Planning Application Reference No.: 3/2024/0090

Address of Development: Land at Eden Gardens (adj 5 Cherry Drive), Brockhall Village, Old Langho, BB6 8HJ

Objection Letter – Planning Reference: 3/2024/0090

Proposal – Proposed construction of one three-storey dwelling and storage building with vehicular access taken from Eden Gardens.

PROPOSED
NORTH WEST ELEVATION (1)

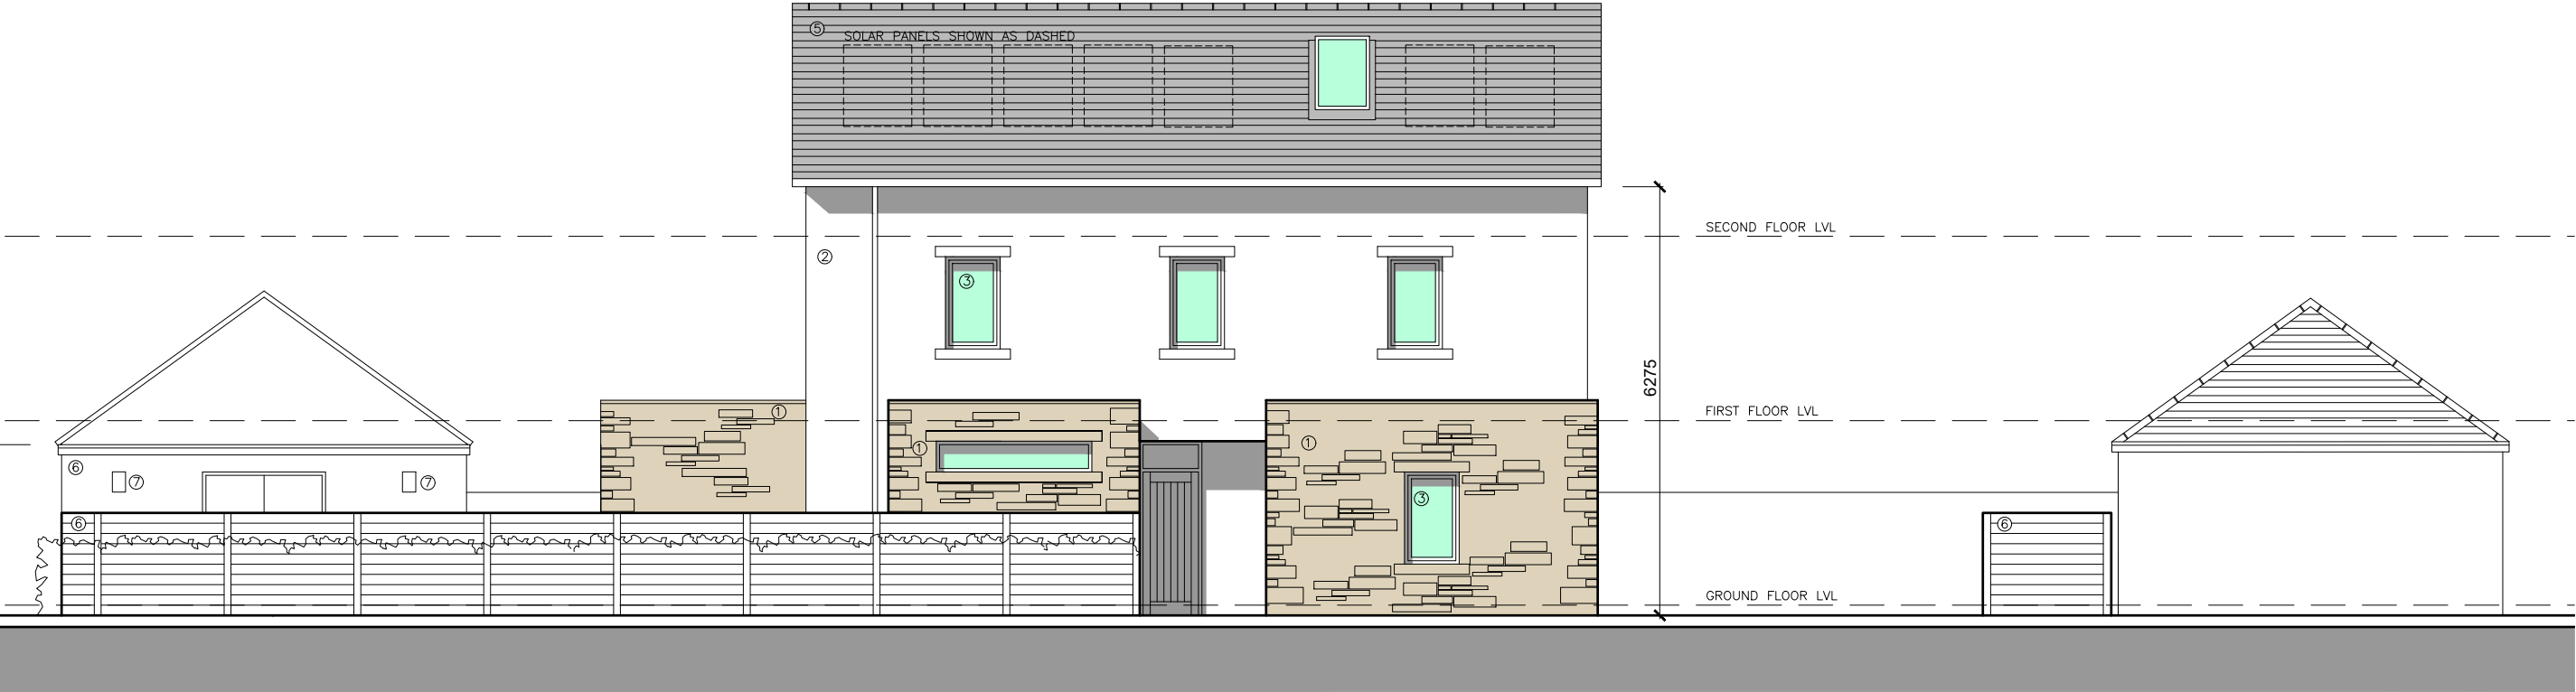
Additionally, the dwelling with high levels of glazing at the front and rear also appears that it is squeezed into the site. Ultimately, the dwelling will appear as contrived and incongruous to the detriment of the character and appearance of this street scene.

As a result of the proximity of the dwelling close to the boundary and its overall, size, scale, mass and poor design, it will appear as an imposing and obtrusive structure from our clients' property that will clearly have an unacceptable overbearing impact. It is evident that the width of the dwelling and its overall height with a pitched roof will accentuate the dominance of the dwelling.
